Subject: Geotechnical Third Party Review  
5637 E. Mercer Way  
Mercer Island, Washington  
Perrone Consulting Project #15124

We have reviewed Geo Group NW October 28, 2015 letter which provides additional subsurface information and geotechnical engineering analyses for the proposed residential project at 5637 East Mercer Way, Mercer Island, Washington. The Geo Group NW submittal was provided in response to our September 4, 2015 letter indicating deficiencies in the geotechnical engineering investigation. This letter summarizes our review of the recent submittal. The item numbers listed here correspond to the items in our September 4, 2015 letter.

**SITE PLAN**

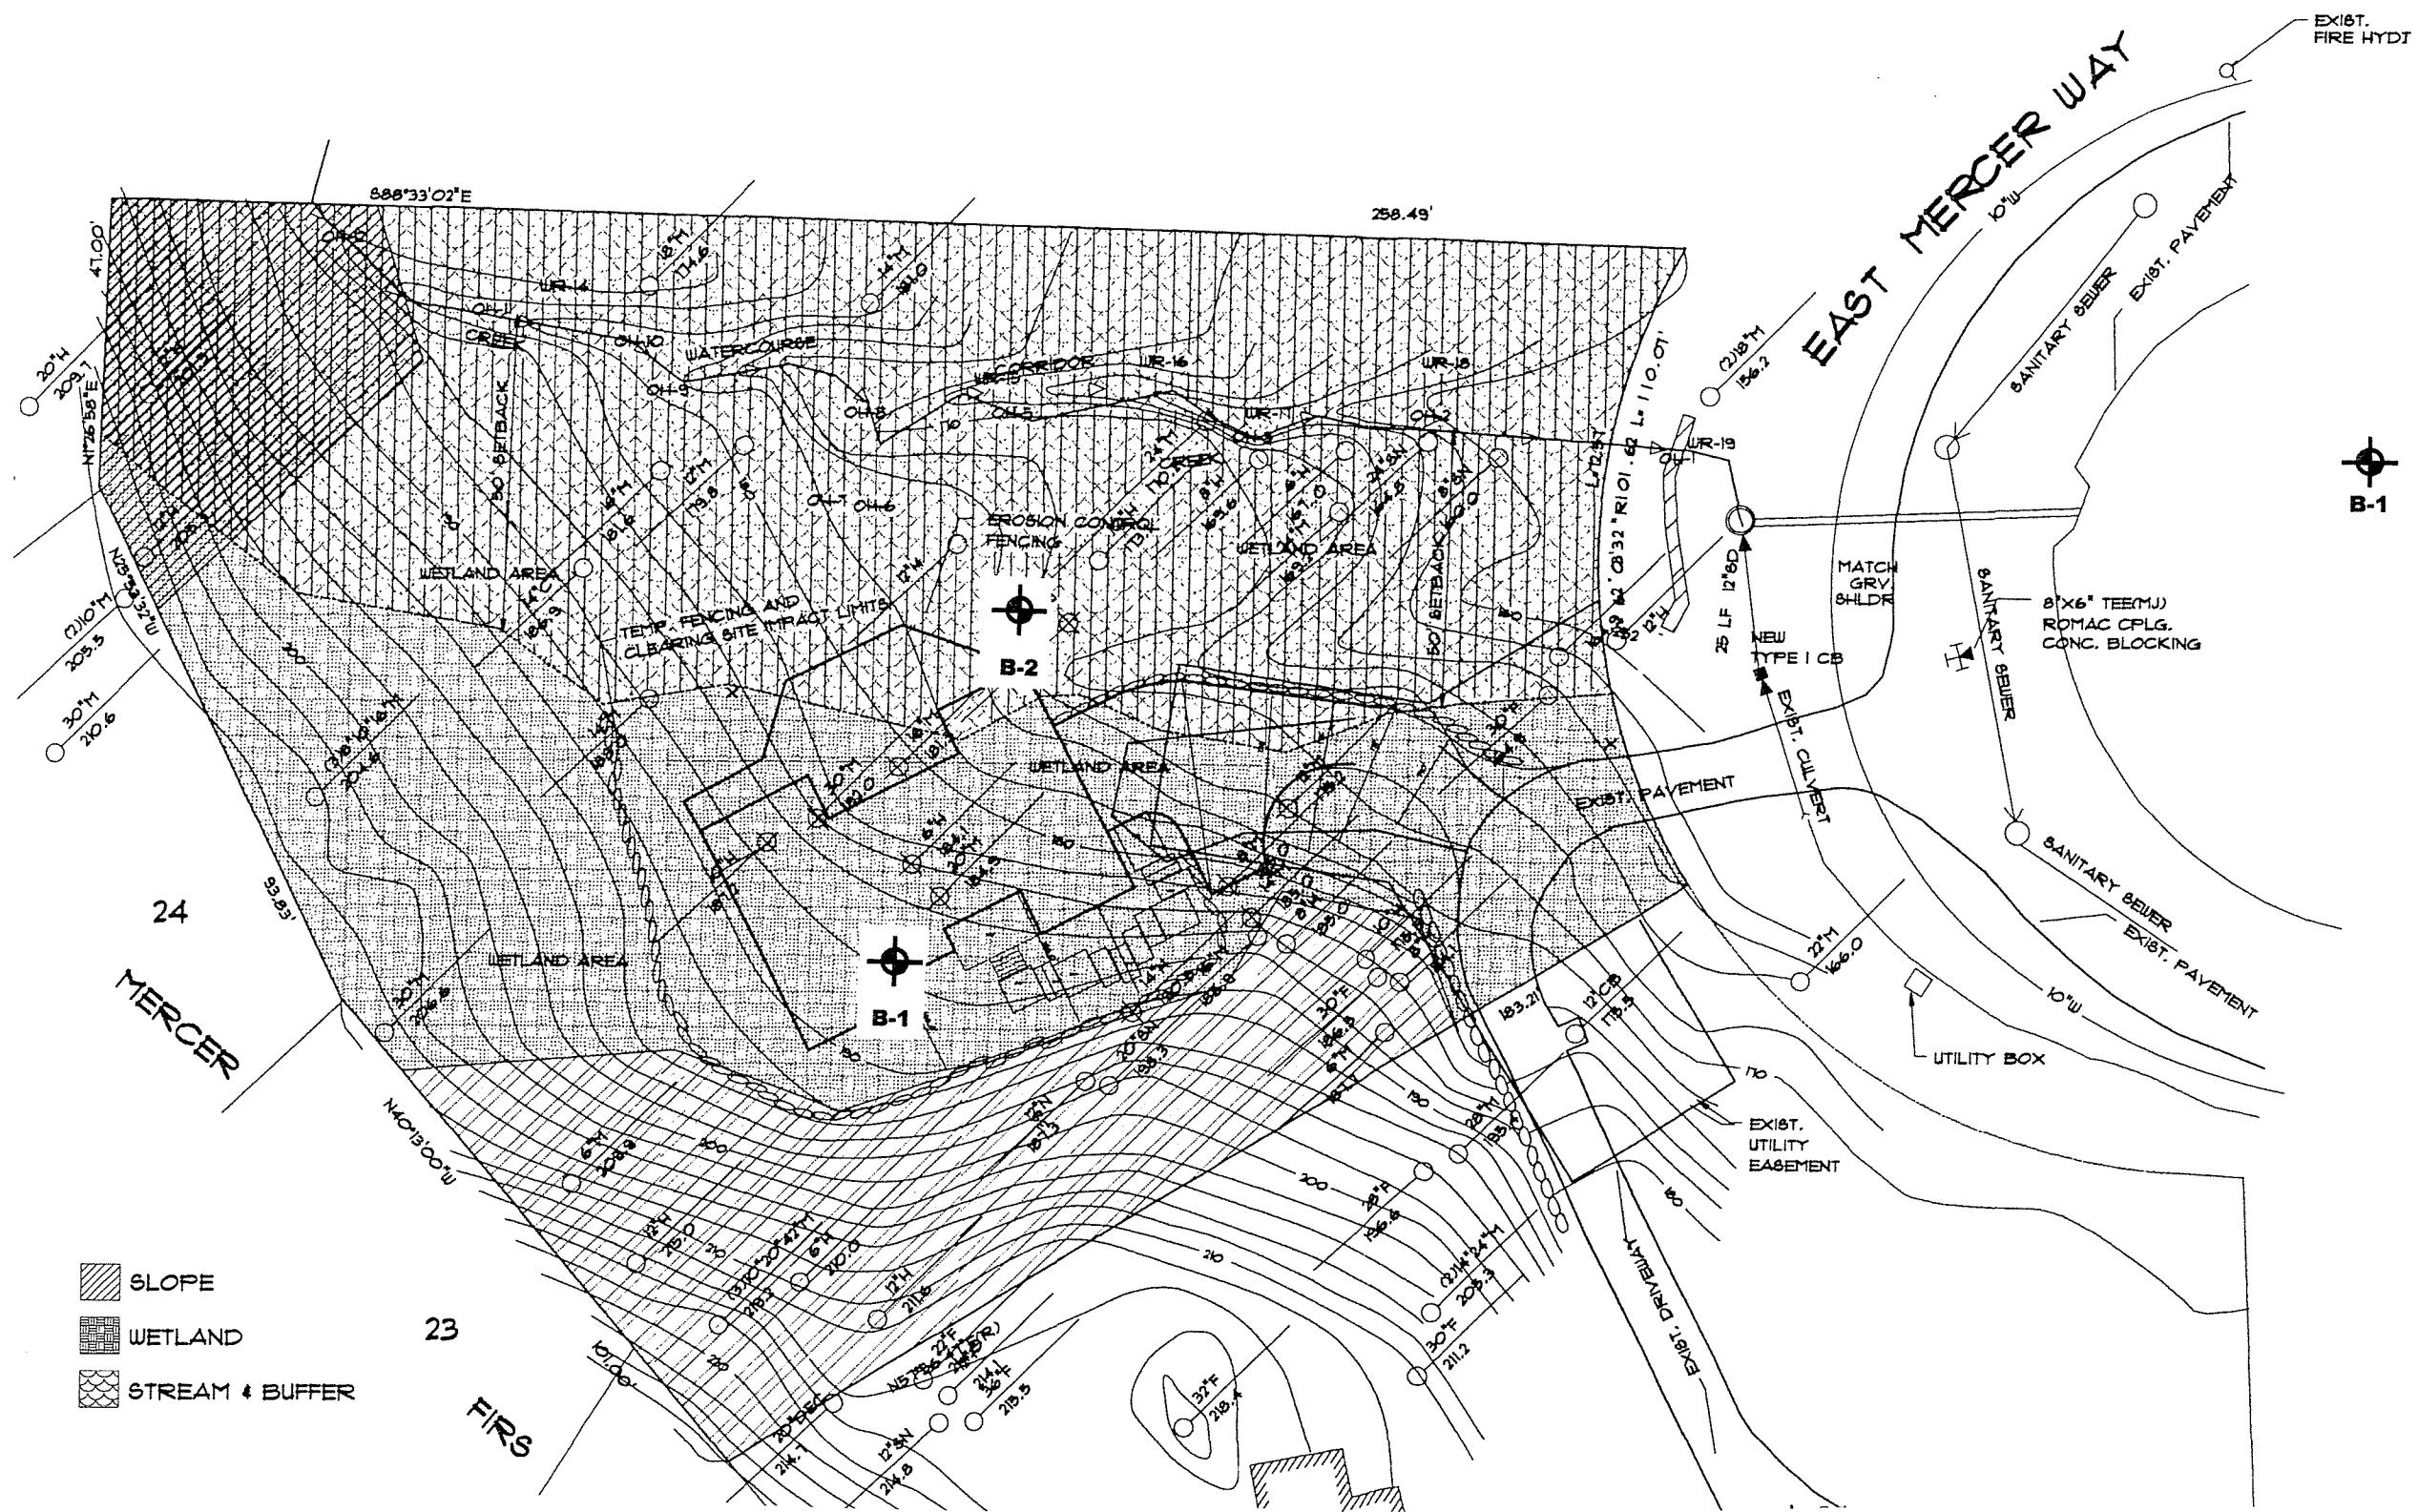
*Provide a site plan with the locations of borings B-1 and B-2 and any additional subsurface explorations necessary to evaluate subsurface conditions on the steep slope.*

The requested information was provided by drilling an additional boring B-3 and providing a site plan with the exploration locations.

**PROPOSED RESIDENCE SECTION**

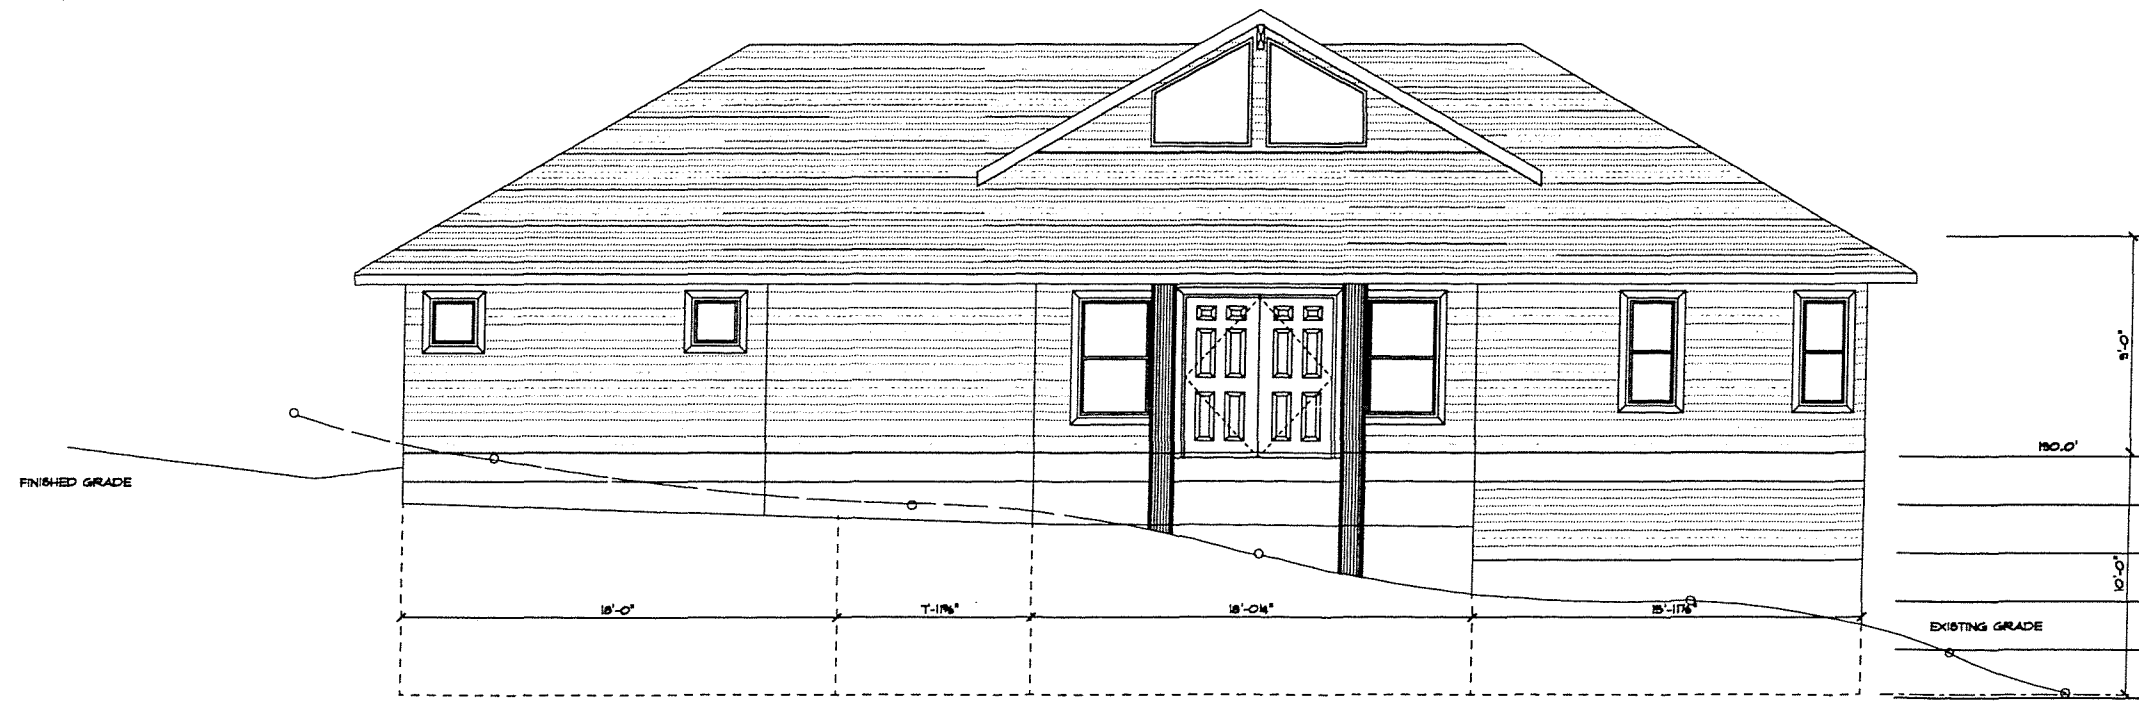
*Provide an interpreted subsurface profile through the critical slope section including the steep slope, headscarp area, and the building site. The profile should include design groundwater levels, engineering soil properties, and the location of the proposed structures.*

The additional boring provided sufficient information to develop the requested subsurface profile which was provided in the submittal along with engineering soil properties. In our opinion Geo Group NW interpretation of Unit 1 in Table 1 as glacial advance outwash is incorrect and should be identified as landslide debris. The Standard Penetration Test blow counts are too low for undisturbed glacial advance outwash soils and the topographic conditions are more consistent with a landslide. However, since we generally agree with the engineering soil properties provided in Geo Group NW Table 1 the submittal provides the requested information.
